**RE: 6L SHORT PLAT, File #SP-07-40**

Kittitas County Community Development Services has determined that the 6L Short Plat is a complete application and hereby grants **conditional** preliminary approval subject to the following conditions:

TO: Mary Rill, Staff Planner, Community Development Services  
FROM: Randy Carbary, Planner II *RC*  
DATE: May 2, 2007  
SUBJECT: 6L Short Plat

6L SHORT PLAT

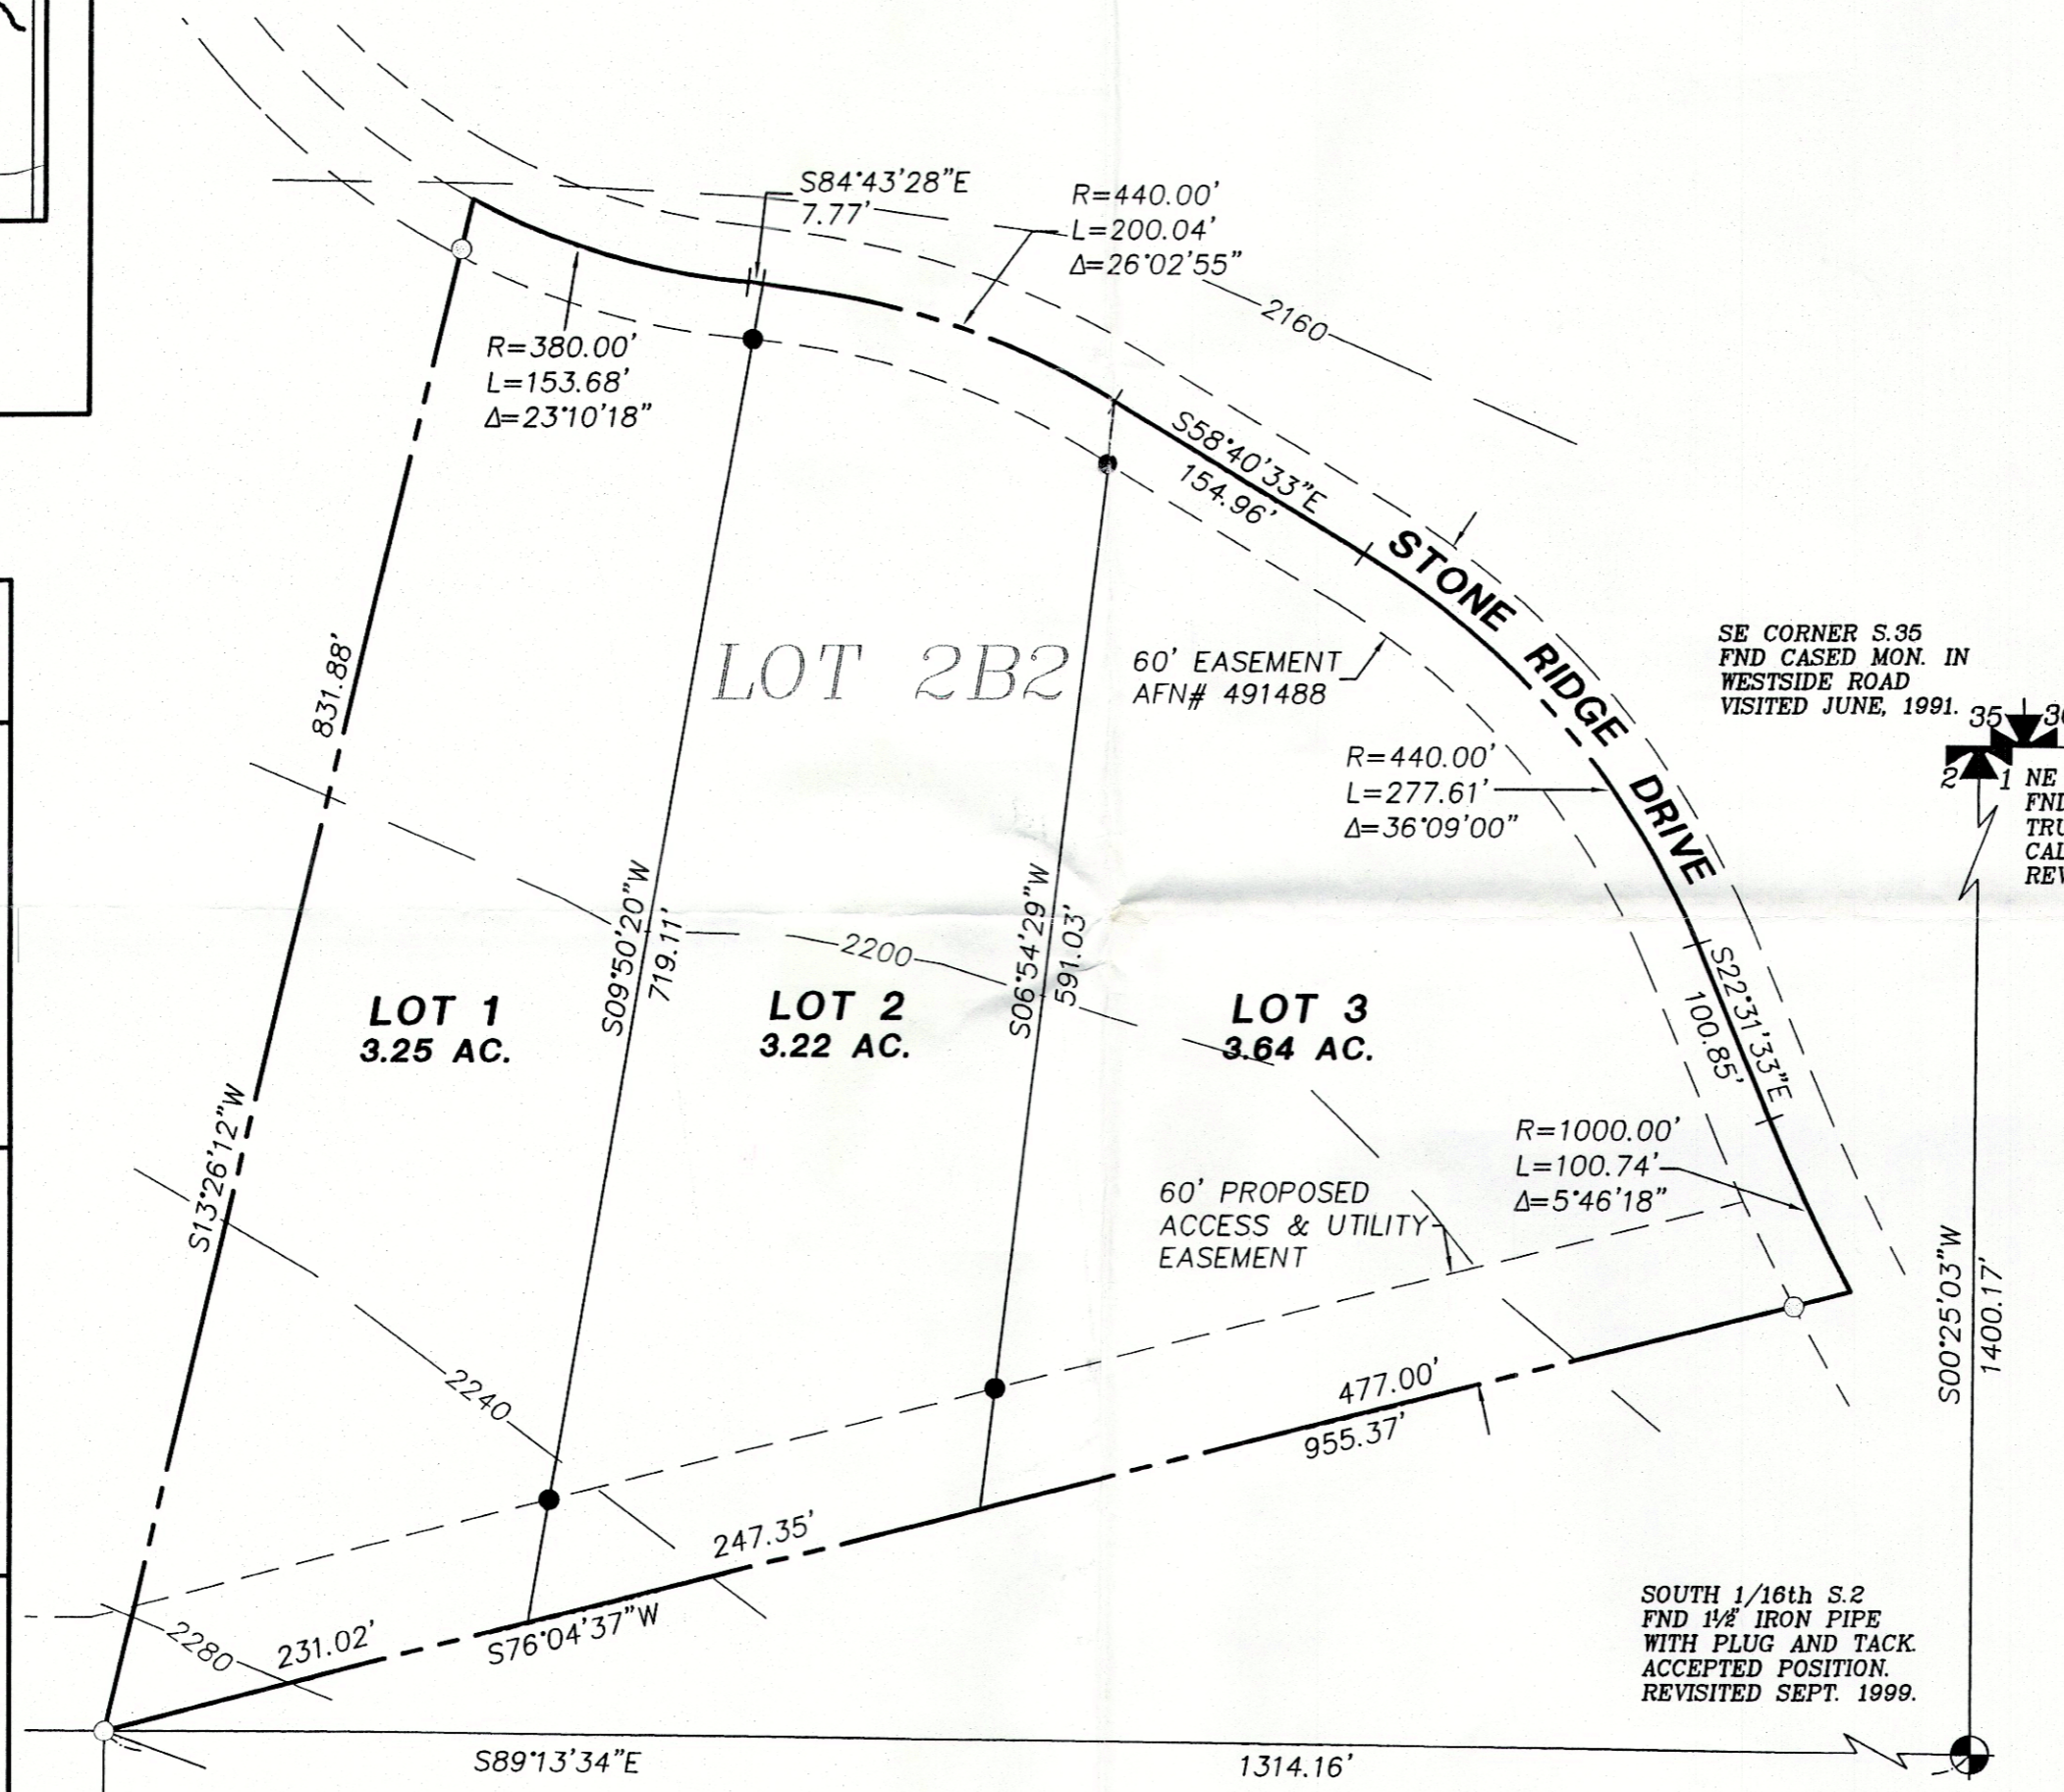
3. Access to Lots 1 thru 3: It appears that lots 1, 2 and 3 may be accessed via Stone Ridge Drive, the 60' access and utility easement, described in AFN 491488 or they may be accessed via the newly proposed 60' access and utility easement that runs along the south edge of these lots. Since this newly proposed easement appears to be serving other lots, as well, the total number of lots served by the easement and average lot sizes are considered when applying Road Standards. According to current Kittitas County Road Standards, all applicable current Kittitas County Road Standards shall be met prior to the issuance of a Building Permit for any of the residence within this short plat.

4. Additional Lots to be Served: The proposed 60' access and utility easement that runs along the south edge of lots 1, 2 and 3 appears to serve other lots, as well. Current Kittitas County Road Standards requires a High Density Private Road to serve these lots. (See current requirements for High Density Private Road shown below). The applicant or their representative should contact our department to discuss future development plans and the number of potential lots served by this access so we can determine the appropriate access requirements.

7. Proposed 60' Access and Utility Easement: The newly proposed 60' access and utility easement that runs along the south edge of lots 1, 2, and 3 shall be constructed as a High-Density Private Road and serve no more than 14 tax parcels. (Per current Kittitas County Road Standards). In addition, a temporary cul-de-sac shall be required near the southwest corner of lot 1. (See current requirements for cul-de-sac shown below).

10. Cul-de-sacs: A temporary cul-de-sac shall be required near the southwest corner of lot 1. Dead-end streets shall have a turn-around having an outside right-of-way easement

- a. Access Easements shall be improved to a minimum of 40'. The roadway width shall be 20', with 1' shoulders = 22' total width.
  - b. All easements shall provide for AASHTO radius at the intersection with a County Road.

- c. Minimum centerline radius will be 60'.
  - d. Surface requirement 6" gravel surface.
  - e. Maximum Grade 8% flat, 12% rolling or mountainous.
  - f. Stopping Site Distance, reference AASHTO.

diameter of at least 110' (55' radius) at the closed end. See Kittitas County Road Standards, 9/6/05 edition.
